COMMENTS:

Operation Permit

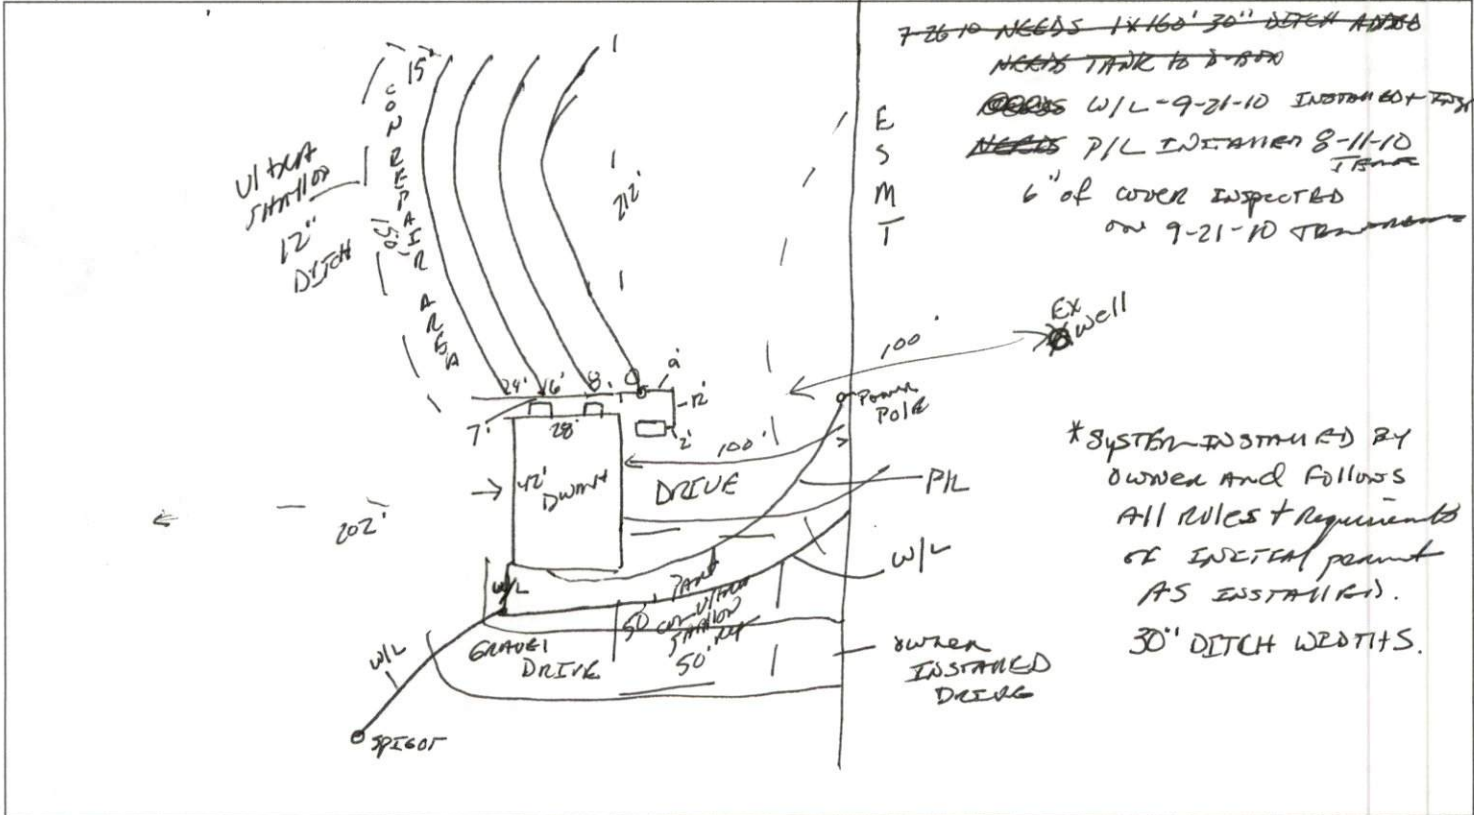
Observed 30" WIDE DITCHES - AND 8' ON Center in some spots

Concrete. NEED TO ADD 1 more 160' (12") DRAIN LINE because

of 6" start in DITCH WIDTH. Showed where to ADD. - Explained

about Tank Placement + Fill. TO D-BOX. Told to make OUTSIDE
EDGES TO DITCHES and cover UP Before RAIN. *RAIN IN DITCHES WAS
NOT ALLOWED.

7-30-10 - went BY and covered completely each LINE. Needs to ADD LINE,
Tank and D-BOX THEN cover WITH Fill AS DESCRIBED. Done

8-10-10 - Visited to inspect 4th 160' LINE. FILL WAS INSTALLED. ADVISED
About Tank + D-BOX placement + Fill to BE added.
